Our ref: HA/2018/120569/01-L01
Your ref: BR/139/18/OUT
Date: 07 August 2018

Outline application with some matters reserved for the demolition of 1 no. Existing dwelling to form access for 6 no. Residential dwellings

Rear of 94-100 Hook Lane, Bognor Regis, PO22 8AT

In the absence of an acceptable Flood Risk Assessment (FRA) we **object** to the grant of planning permission and recommend refusal on this basis for the following reasons.

FLOOD COMPENSATION AREA

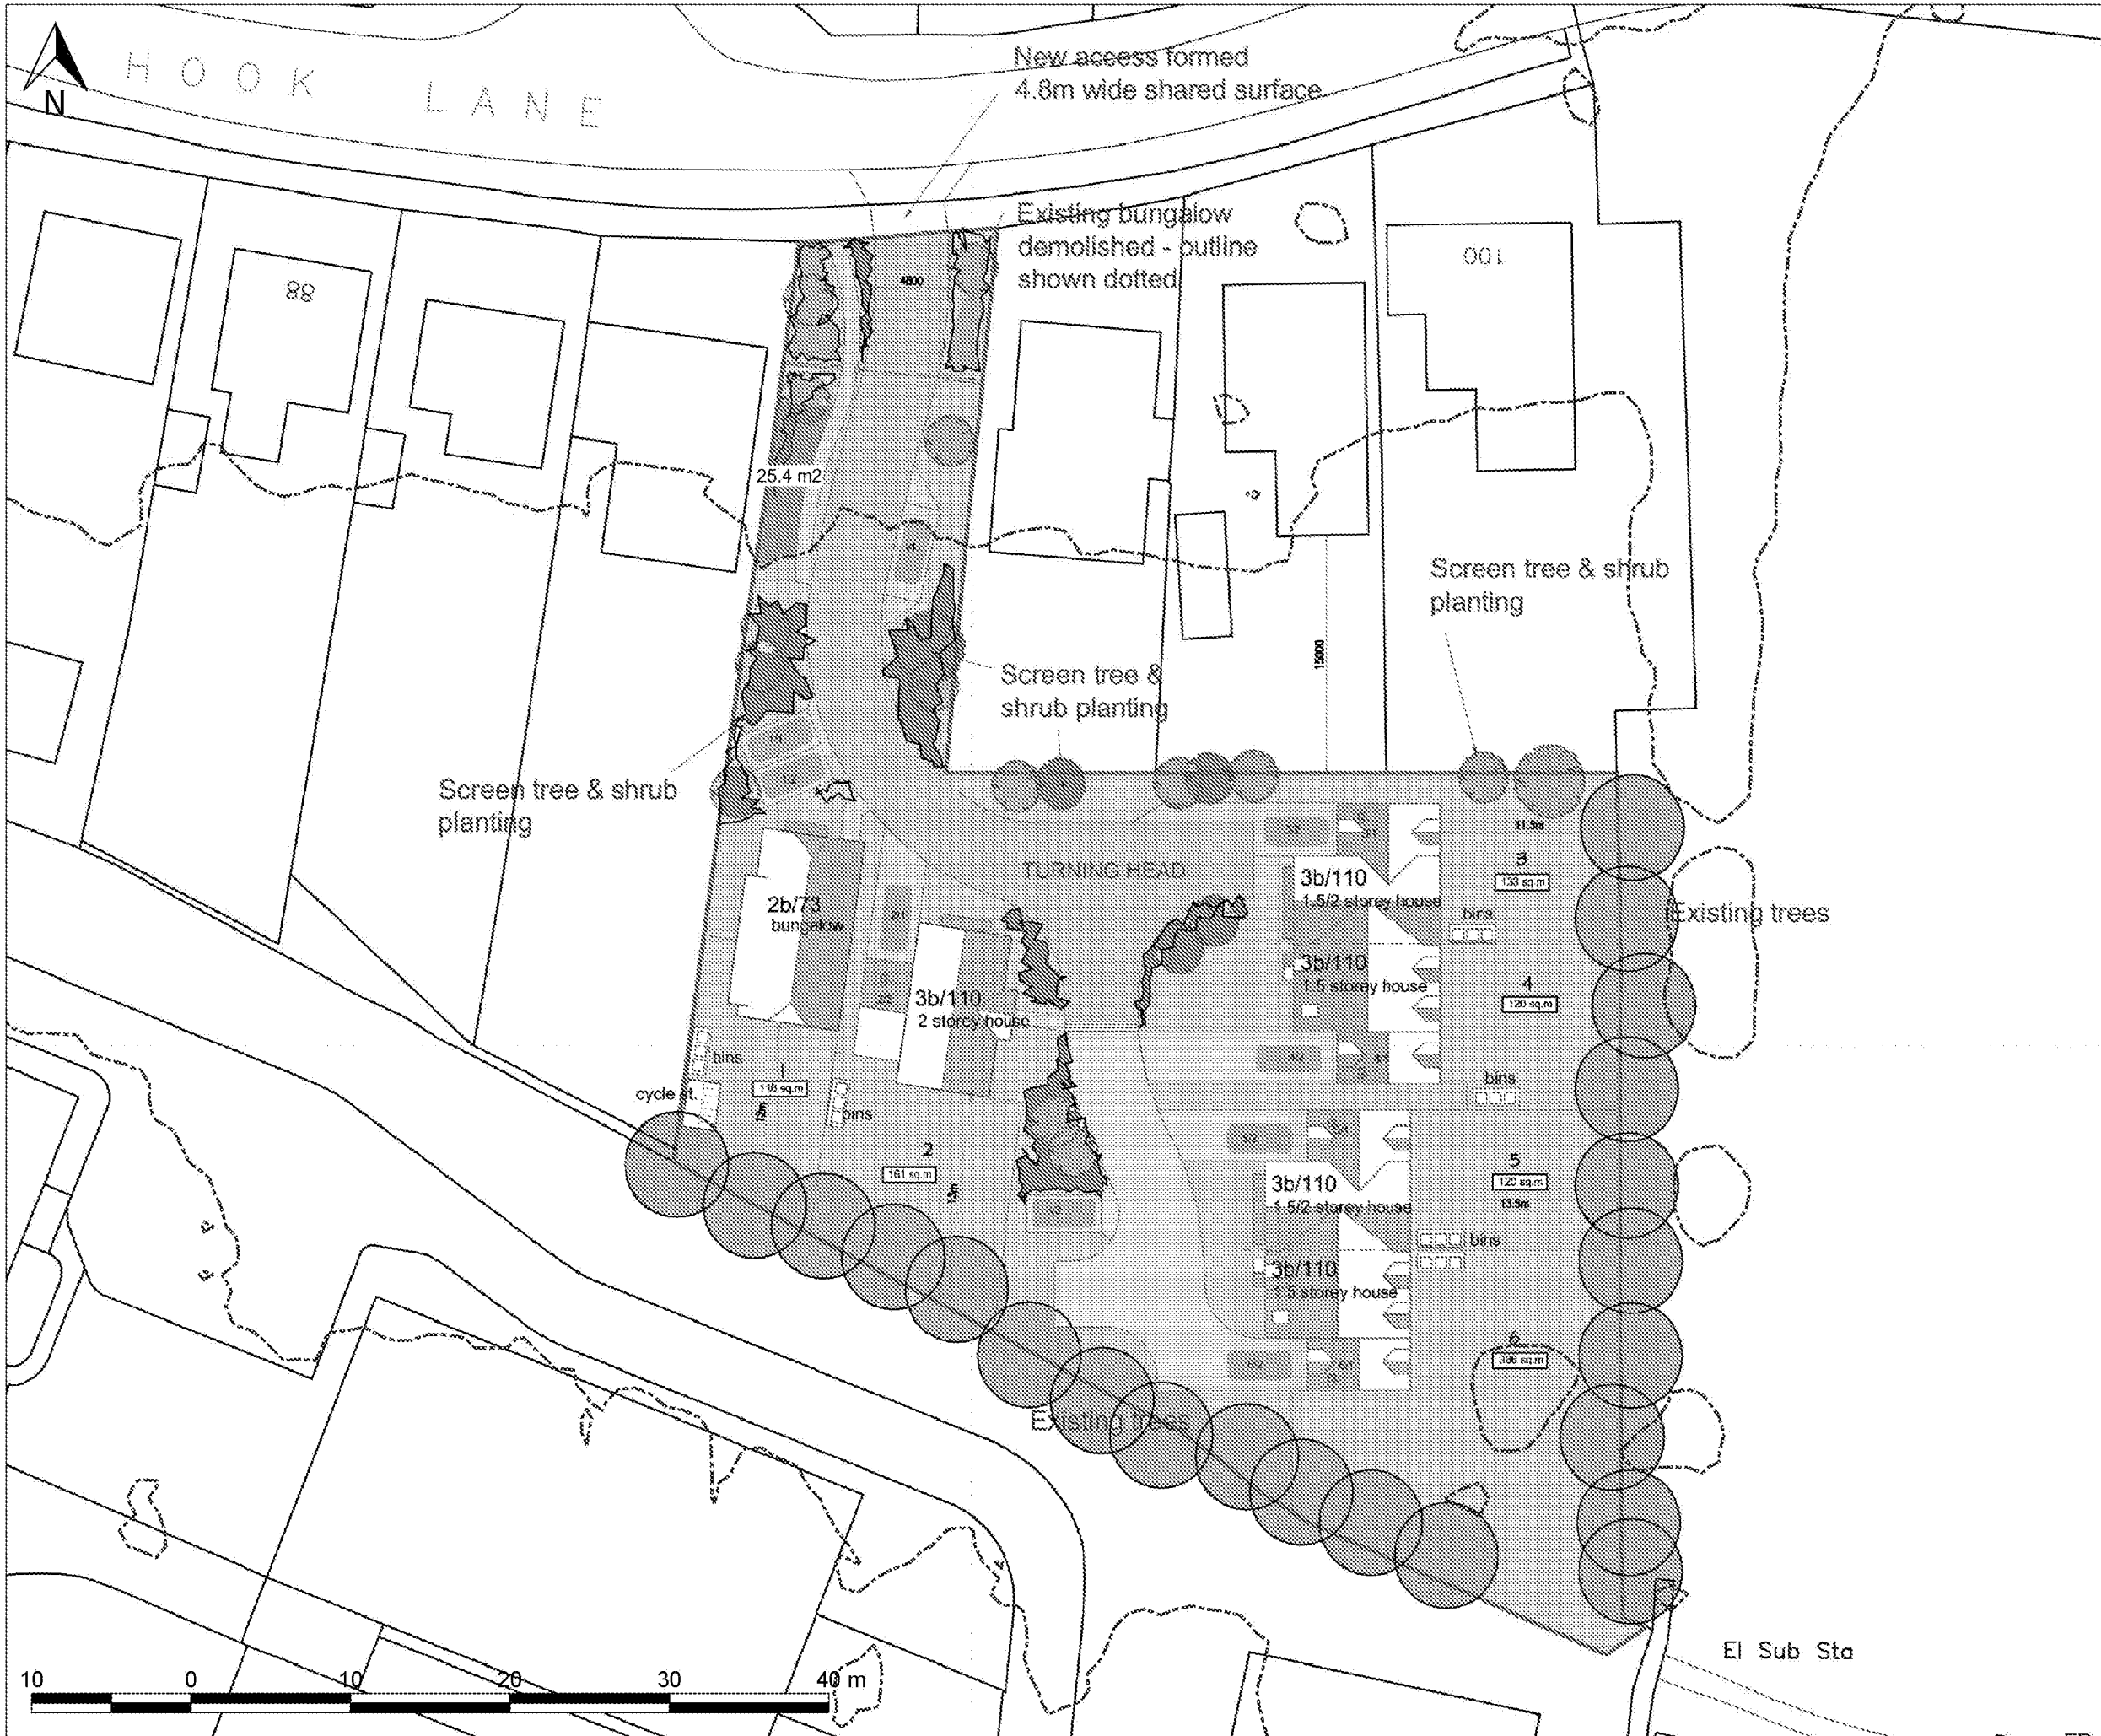
- More information about the proposed flood compensation is needed. Basic requirements for compensatory floodplain storage are as follows:
- A volume of floodplain equal to or larger than that lost to the proposed development must be created

- The volume must apply at all levels between the lowest point on the site and the design flood level. Normally this is calculated by comparing volumes taken by the development and the volume offered by the compensatory storage for a number of horizontal 'slices' through the range defined above

- The thickness of a vertical slice should typically be 0.2 metres. In the case of large flat sites or very steep sites this may be varied, for example for flat sites to 0.1 or even 0.05 metres. The slice thickness should be set to provide between ten and fifteen slices for such unusual sites.

- Due to the lack of information, it is not clear if it is proposed to use stilts or voids. This is not floodplain compensation, but rather mitigation of risk by design. The use of stilts reduces the impact on the development but does not guarantee that the floodplain will be retained in the same way as a compensation scheme (which is a form of risk substitution).

You can overcome our objection by submitting an FRA which covers the deficiencies highlighted above and demonstrates that the development will not increase risk elsewhere and where possible reduces flood risk overall. If this cannot be achieved we are likely to maintain our objection to the application. Production of an FRA will not in itself result in the removal of an objection.
